**CENTRAL BEDFORDSHIRE COUNCIL COMMENTS ON DEADLINE 8
SUBMISSIONS**

LONDON LUTON AIRPORT EXPANSION DEVELOPMENT CONSENT ORDER

5. REP8- 029 Applicant’s Response to ISH4 AP7 – Updates on Road Safety Audits

Figure 3.4: A1081 New Airport Way- Proposed Layout

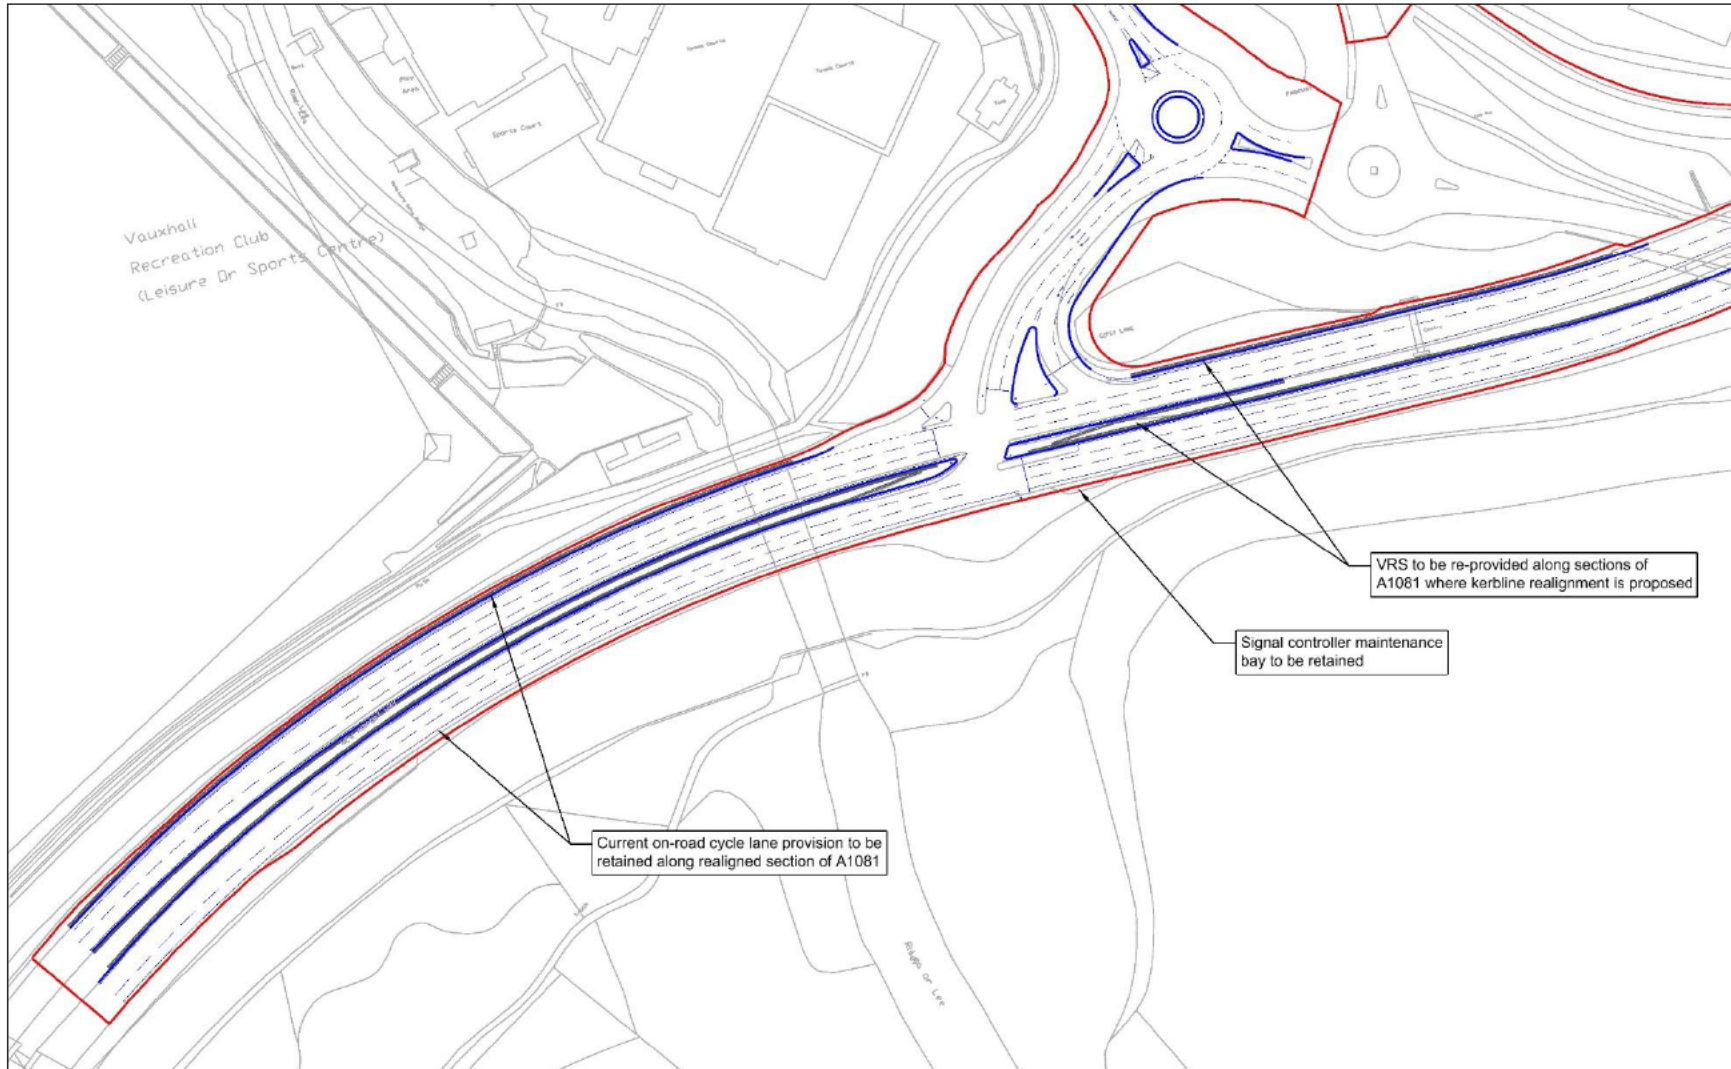
With regards to Safety Audit Problem 3.7, having taken on-site measurements of the existing layout, it appears that the existing cycle lane on the A1081 northern side (which was the only element safely accessible to obtain measurements) has a width of between 1.4 and 1.5m. As such the revised proposals would result in the further narrowing of what are already narrow cycle lanes, with a proposed width of 1.2m. CBC would also note that the recommended absolute minimum width of a cycle lane in LTN 1:20 table 5.2 is 1.5m).

When considered in combination with the proposed 3.0m running lanes immediately adjacent to the cycle lanes, this would bring vehicular traffic closer to cyclists on a substandard width cycle lane, and with less scope for drivers to give room to those cyclists, due to the narrowness of the running lanes. As such the designer's response is not agreed.

Figure 3.5: Indicative A1081 Cross Sections

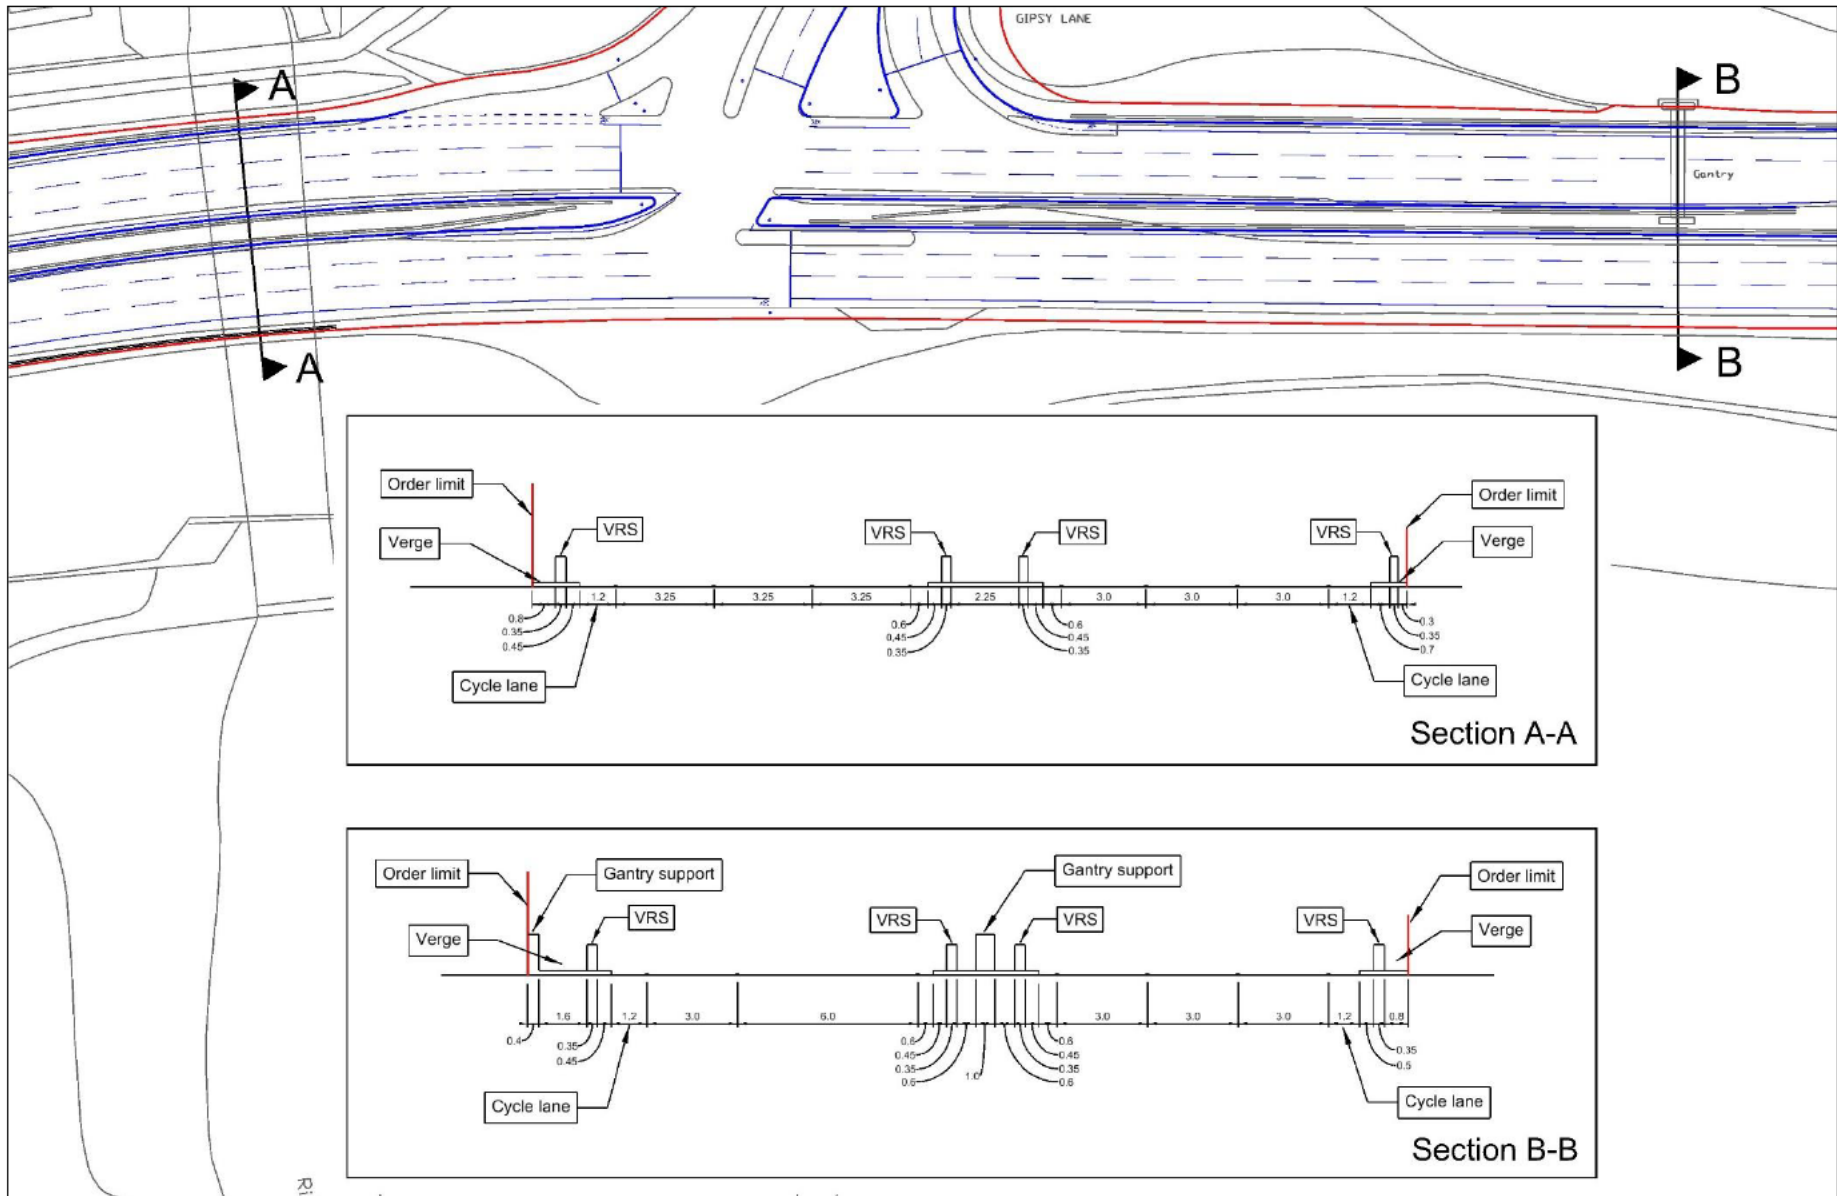
With regards to Safety Audit Problems 3.1 and 3.7, it is noted that the updated Safety Audit Designers Response includes cross section plans of the proposed revised scheme taken at two points on the A1081 provided as Figure 3.5 to demonstrate what can be achieved within the order limits. These appear to show a minimum permissible offset between the edge of carriageway and the existing VRS of 0.45m, minimum recommended lane widths of 3.0m, and cycle lanes reduced in width to 1.2m.

With regards to Safety Audit 3.1, the revised cross section shows a reduced level of clearance between the RRS and the gantry footing, at 0.6m. The Safety Audit recommendation is that 'It should be ensured that the items of street furniture can be adequately protected by vehicle restraint systems, without encroaching into the working width of the VRS.' Whilst the designer's response accepts the recommendation, and states that this would be addressed at detailed design stage, CBC concern is as previously stated, i.e.: that there may not be sufficient available width within the DCO limits to achieve this, with no information provided as to the working widths which would need to be provided for, and with the submitted cross

sections already working on the basis of minimum lane widths, clearances, and reduced cycle lane widths (on which further comment is made later).

It is also noted that the designs at present are at a feasibility level of detail and appear to be on an OS base rather than a topographical surveyed base. As such there is likely to be a further degree of potential variation in terms of actual available widths, with OS base mapping not being fully accurate or representative of on the ground conditions. As such the designer's response is not agreed, as CBC do not have full confidence that a design standards compliant scheme can be achieved within the order limits.
